CITY OF ALBUQUERQUE

6/12/2025

**RE: Mesa del Sol Regional Sports Complex
5601 University Blvd. SE
Drainage Master Plan
Engineer's Stamp Date: 3/5/2025
Hydrology File: R15D002B**

Based upon the information provided in your submittal received 6/5/2025, the Drainage Master Plan **is not** approved for Grading Permit. The following comments need to be addressed for approval of the above referenced project:

BERNALILLO COUNTY PUBLIC WORKS DIVISION TECHNICAL SERVICES	
TITLE: MESA DEL SOL TOURNAMENT FIELDS	
DRAINAGE PLAN	
Design Review	County Engineer Approval
Last Design Update	
Mo./Day/Yr.	Mo./Day/Yr.
NO.	DATE
REMARKS	REVISIONS
BY	
COUNTY PROJECT NO. PWDN2025-0031	
Zone Map No. R-15	Sheet DR

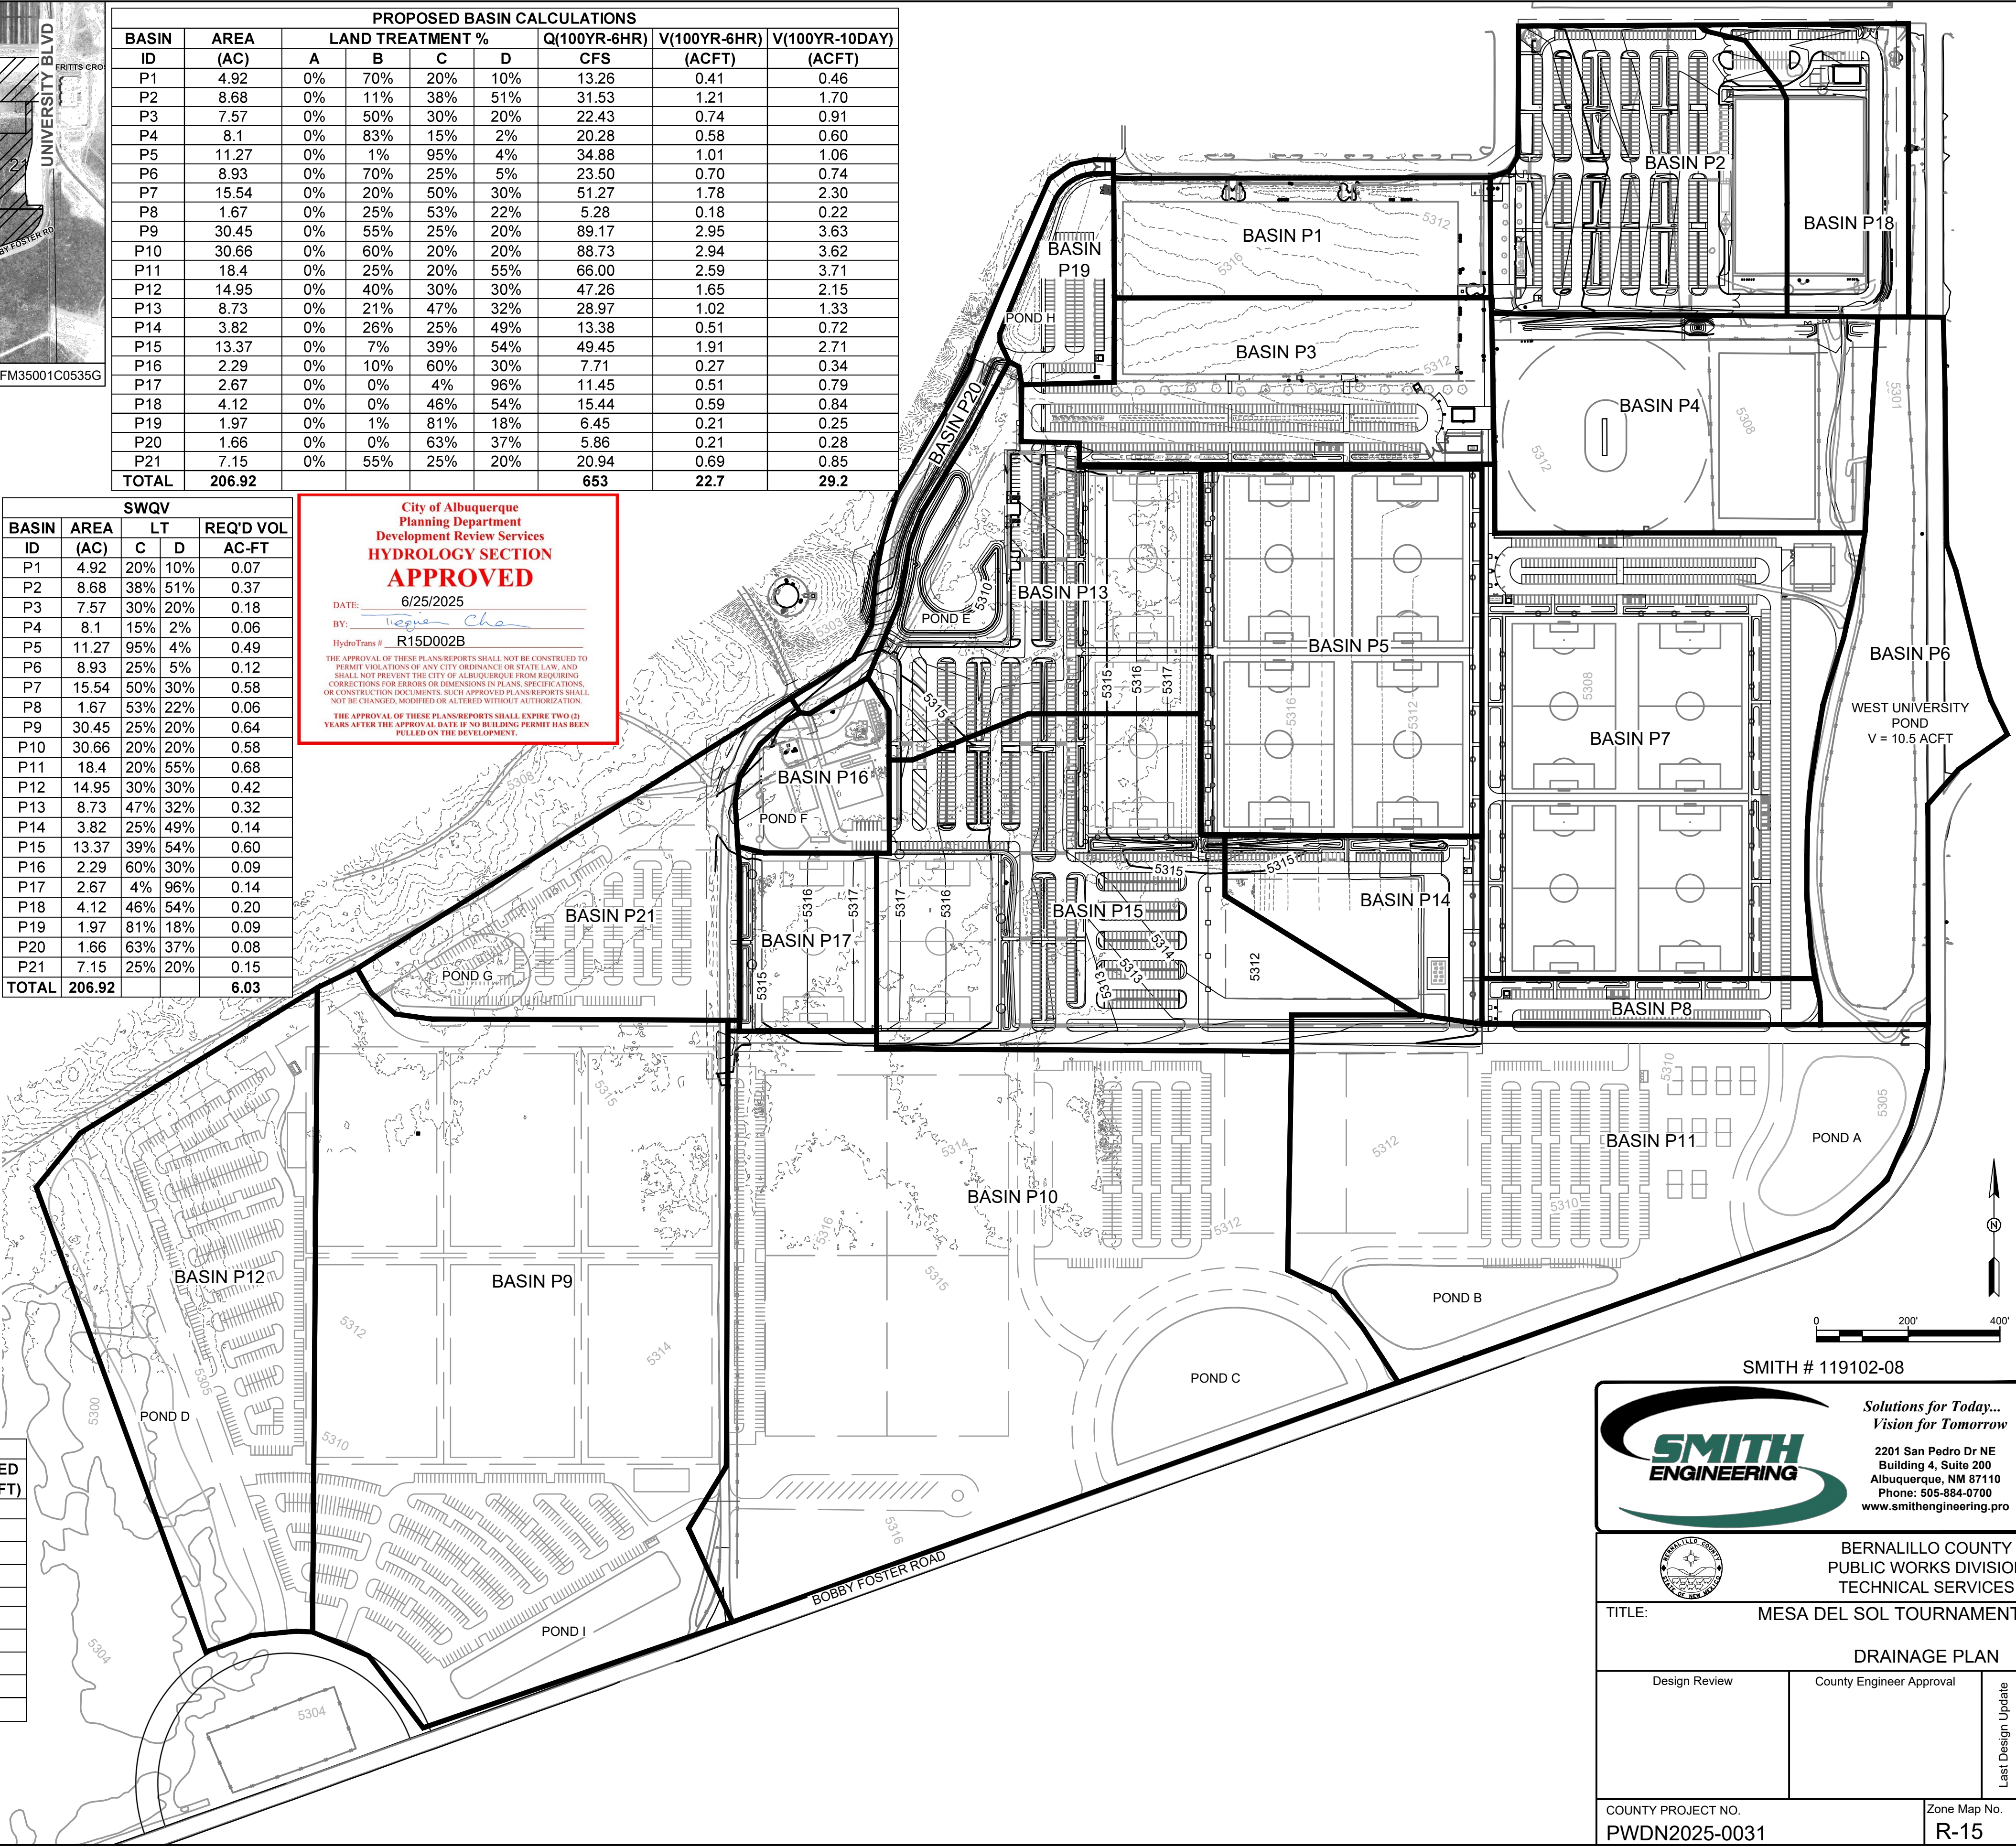
1. Please add a vicinity map.
2. Provide the FIRM Map and floodplain note with effective date.
3. Add phasing plan.
4. Change the site location from "Northeast" corner to "Northwest" corner in "Background".
